Road Safety Audit Stage 1

Location: Bairds Farm Shop / New Care
Home Access A259 Crookthorn Lane,
Littlehampton
Section 278 Highway works

Date 7th March 2018

Report Title: Stage 1 Road Safety Audit
Section 278 Highway Works

DRAWING TITLE
Highway Improvements

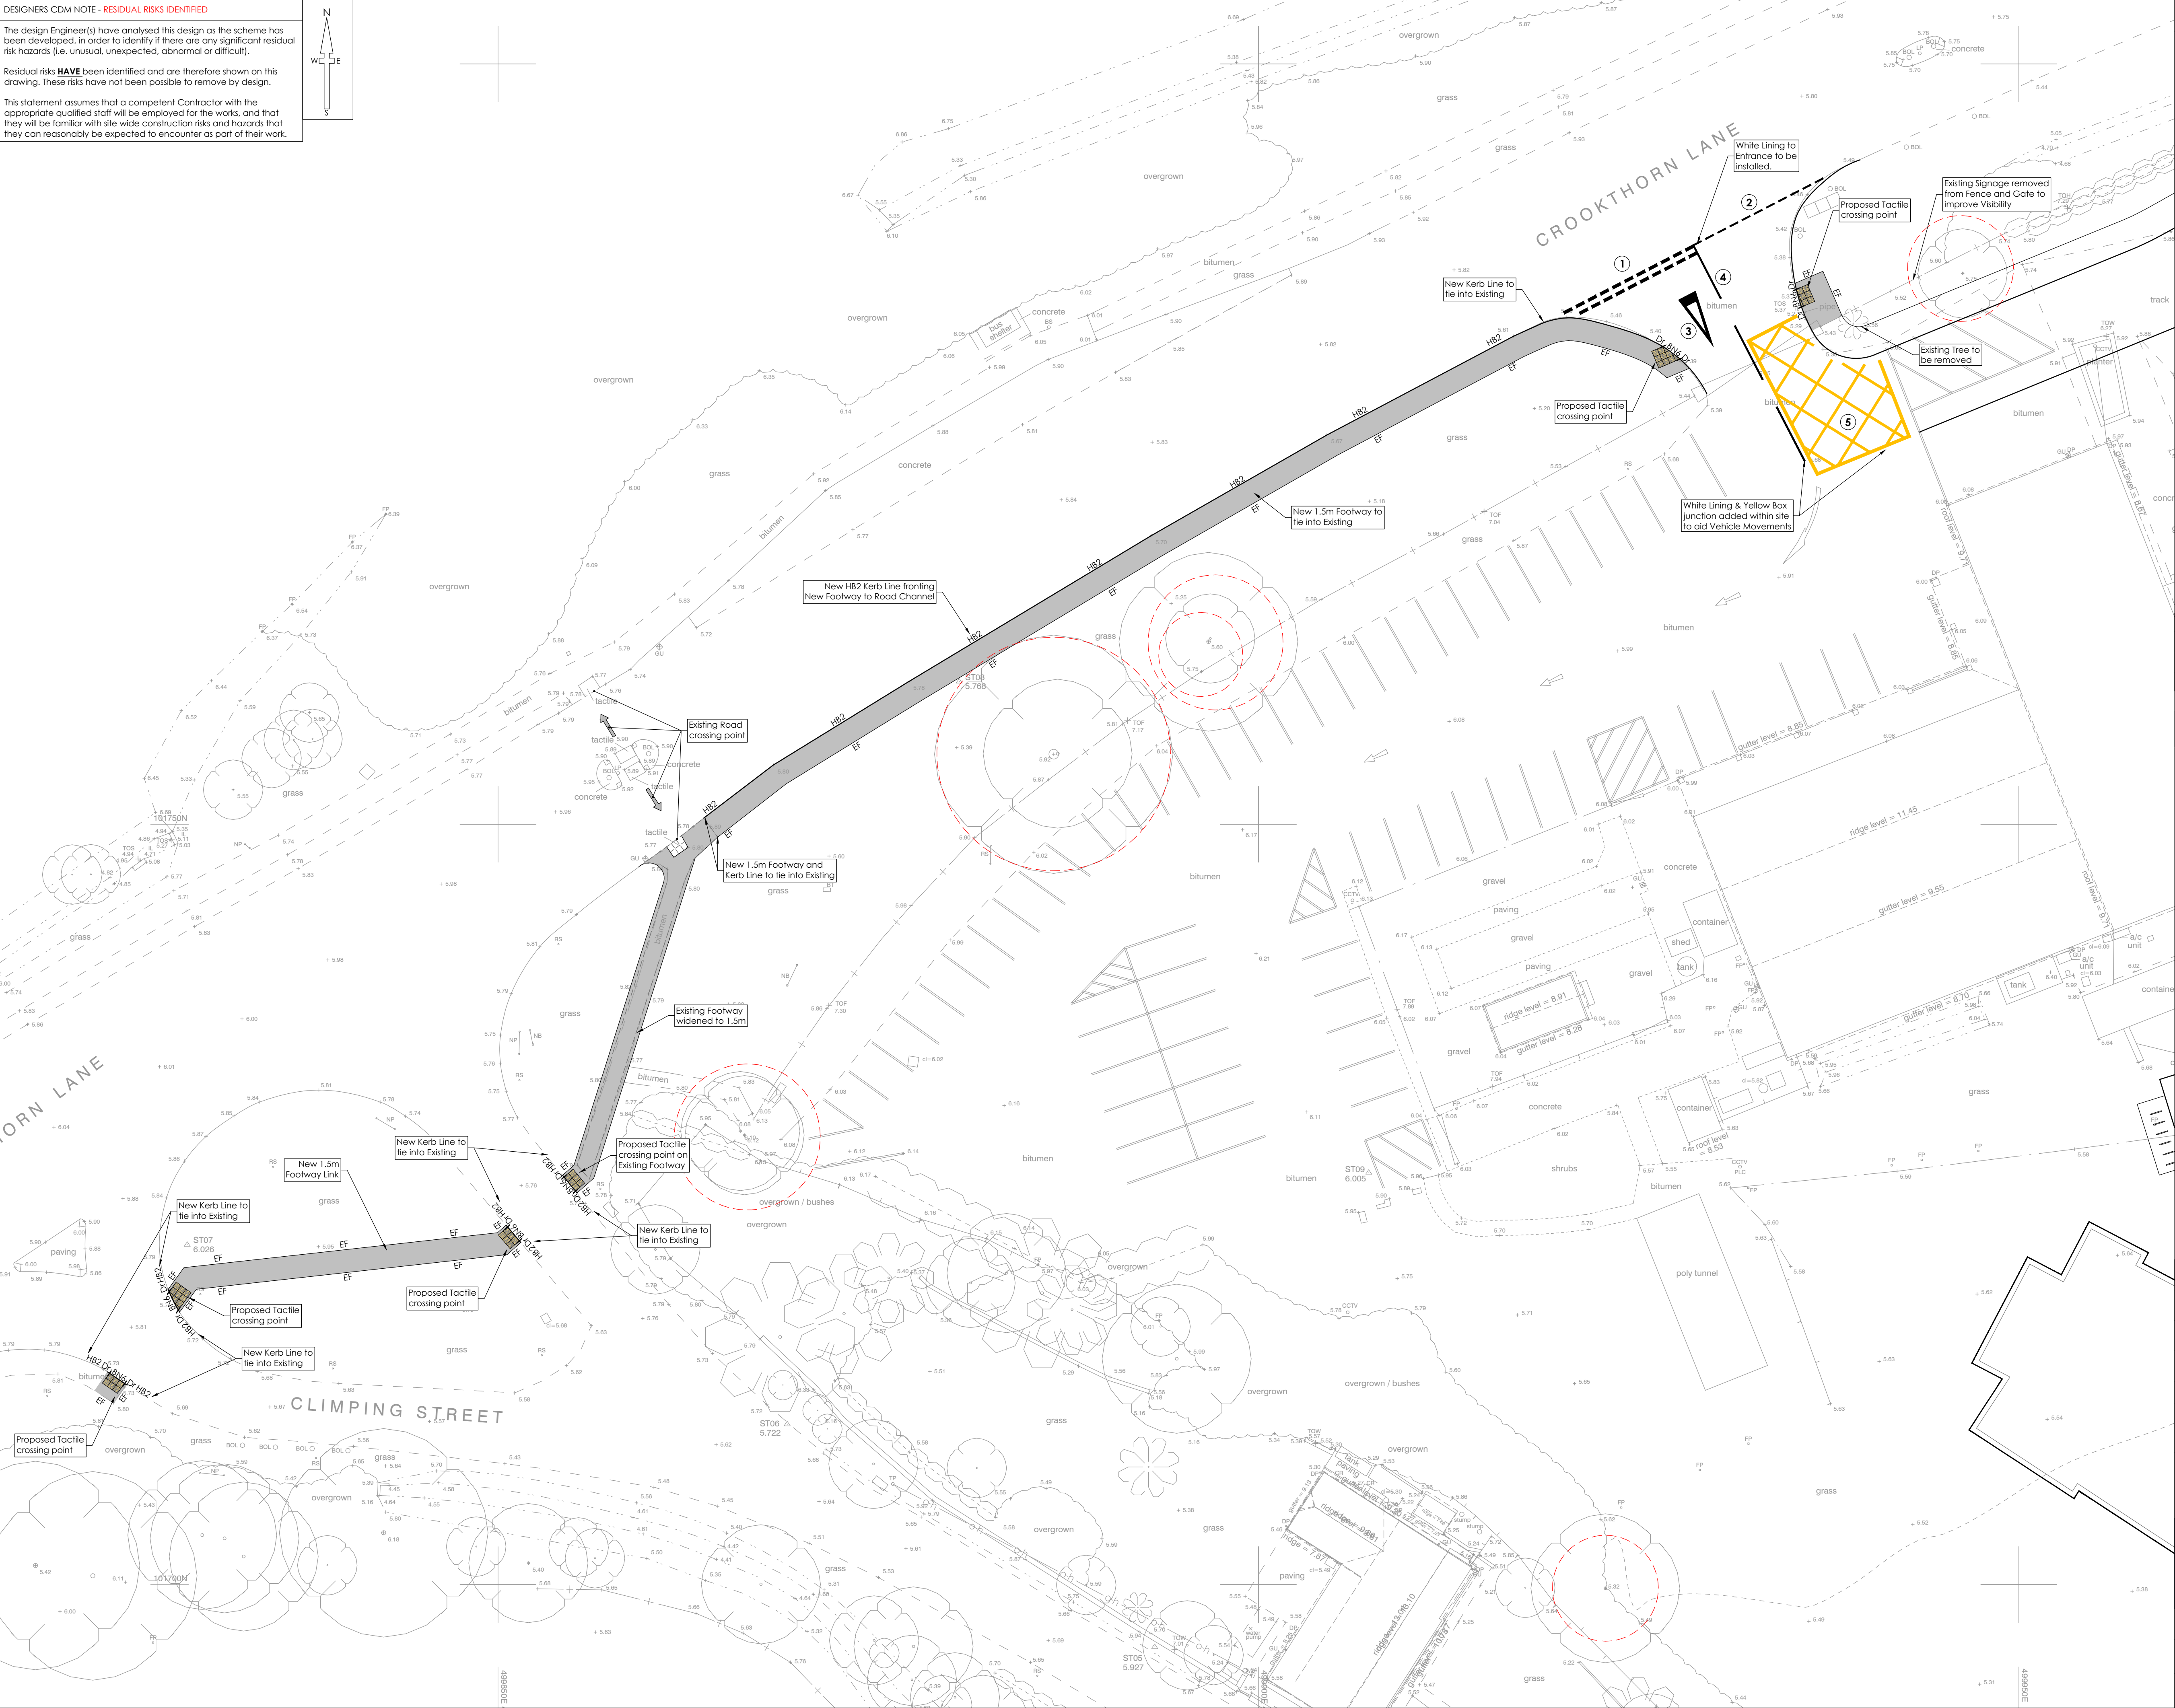
Description: The existing access only has an edge of carriageway give way marking and no centre line on the side road approaches. The give way marking needs to be changed to the

standard marking and centre warning lines provided on the approach from the shop car park past the new access from the care home up to the A259 to ensure opposing vehicles keep to the left and not block the path of vehicles coming in the opposite direction

Recommendation: Provide appropriate give way markings and centre line on approach from farm shop

Description: A new internal junction is detailed into the care home immediately after you exit from the A259. Appropriate give way markings with box junction needs to be provided to ensure vehicles exiting from the A259 have priority and to avoid vehicles tailing back onto the A259.

Recommendation: Provide junction give way marking

Description: A new side road junction is detailed within the site immediately after you exit from A259. There is a gate, fence, and vegetation that obstructs visibility of vehicles accessing the site from the A259 for vehicles exiting from the care home. These need to be removed and appropriate clear visibility splays provided

Recommendation: Ensure clear visibility at internal junction

Description: A new care home is being provided. It is likely that pedestrians will want to access the new development. There is no footway link from the existing pedestrian crossing point that services the bus stop on the northern side of A259 to the development site. The new development will generate some pedestrian visitors/workers who will travel by bus. A footway link needs to be provided across the farm access and along the A259 to link up with the existing path.

Recommendation: Provide new length of footway and crossing point across access along A 259

Description: A new footway is detailed from the development out onto the A259. There is no central pedestrian refuge island on the A259 to enable pedestrians to cross the road only a central island. This island needs to be changed to a pedestrian refuge and appropriate dropped kerb /tactile paving crossing point provided

Recommendation: Provide appropriate refuge island and crossing point at end of new footway
